From: planning@welhat.gov.uk
To: [Planning Comments \(Shared Mailbox\)](#)
Subject: New comments for application 6/2024/0071/HOUSE
Date: 12 February 2024 04:28:33

New comments have been received for application 6/2024/0071/HOUSE at site address: 38 Barleycroft Road
Welwyn Garden City AL8 6JU

Address:
36 Barleycroft Road, Welwyn Garden City AL8 6JU

2 38 Barleycroft Road
Roof plan 1:100

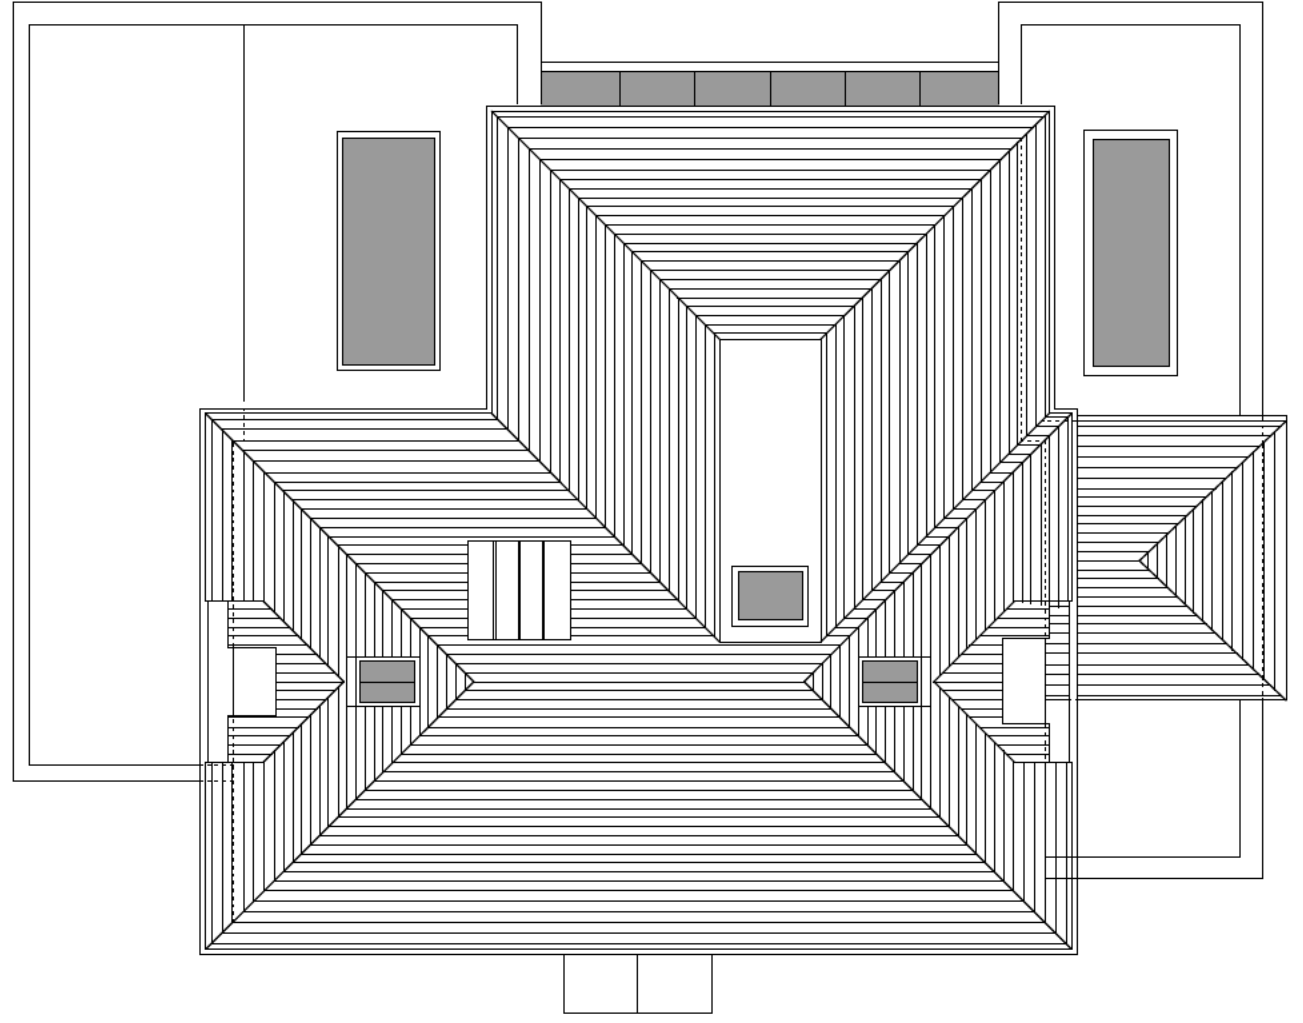
It is appreciated that the proposed extension reflects the character of the Garden City conservation area. However, the proposed parapets to the front elevation are much higher than the existing levels and are curved upwards to join the existing first floor flank elevations. This is not in keeping with the character/appearance of this attached-detached terrace of houses at 32-38 Barleycroft Road where parapets are at a much lower level or non-existent and level. As the site of this terrace slopes down from 38 to 32 the increased height of the parapet will be particularly noticeable from the roadway with a much higher flank wall than the existing wall adjoining the driveway of 36. Also the existing tiled roof to the ground floor workshop of 38 will form a large breach in the proposed parapet wall on the eastern boundary with 36 where it partially overflies the flat garage roof of 36. This breach and protruding tiled roof will be very visible from Barleycroft Road and not in keeping.
